File No: NTH11/00158
Your Ref: SSD 7480

Kamilaroi Highway [HW29]: SSD 7480 - Notice of Exhibition - Vickery Coal Mine Extension Project - Blue Vale Road, Gunnedah

VICKERY EXTENSION PROJECT
 Indicative Kamlaroi Highway
 Overpass Design

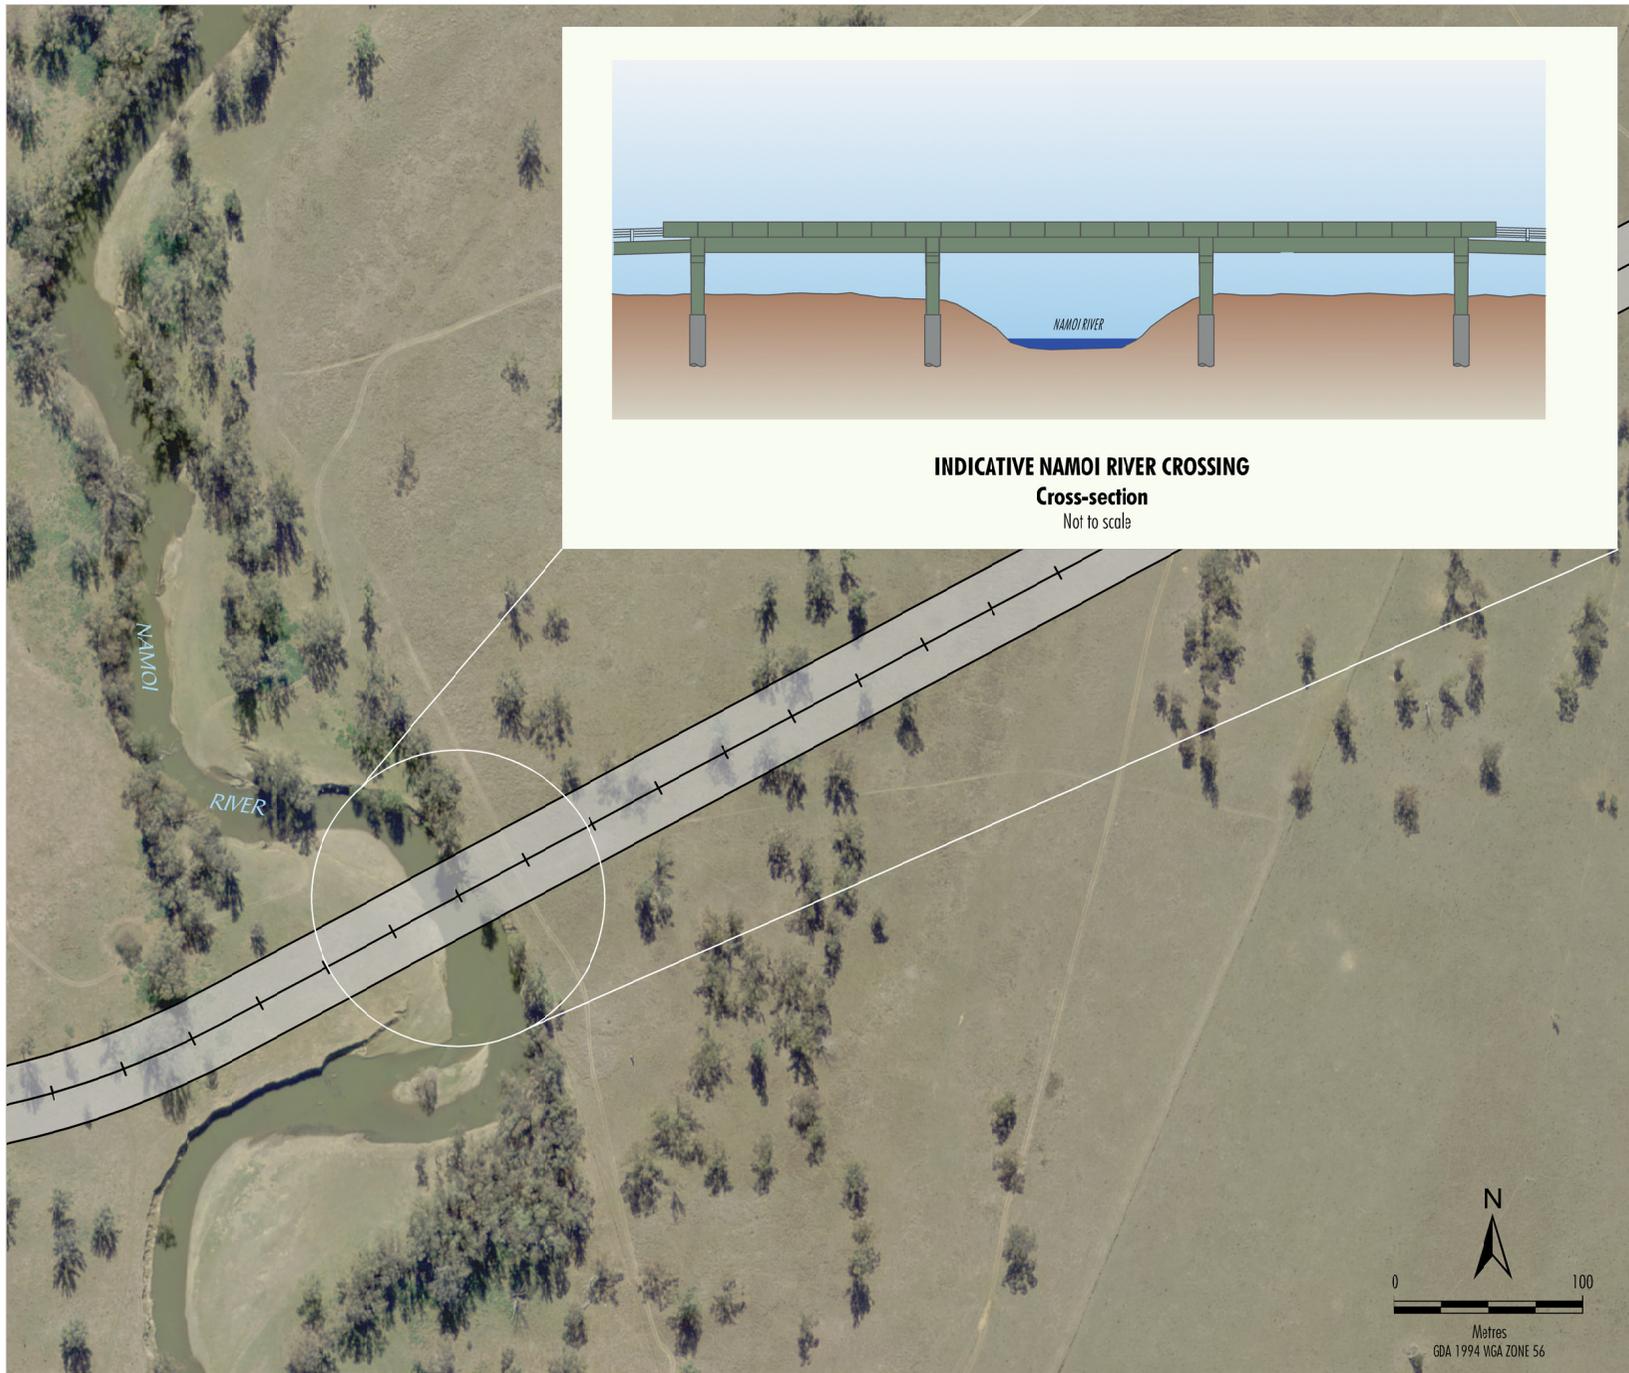
- Details for the proposed rail loop and spur including the proposed Kamilaroi Highway rail-over-road overpass, shown in both the EIS, Section 2 - Figure 2.8 and Appendix L – Figure 17, are indicative conceptual drawings only and would need to be constructed under a WAD. Detailed design plans, including a Road Safety Audit, will be required as part of the WAD process.
- It is unclear if the proposed rail-over-road overpass goes ahead, that the previously approved road-over-road overpass near the Whitehaven Coal Handling Processing Plant will still be required. This needs to be clarified.
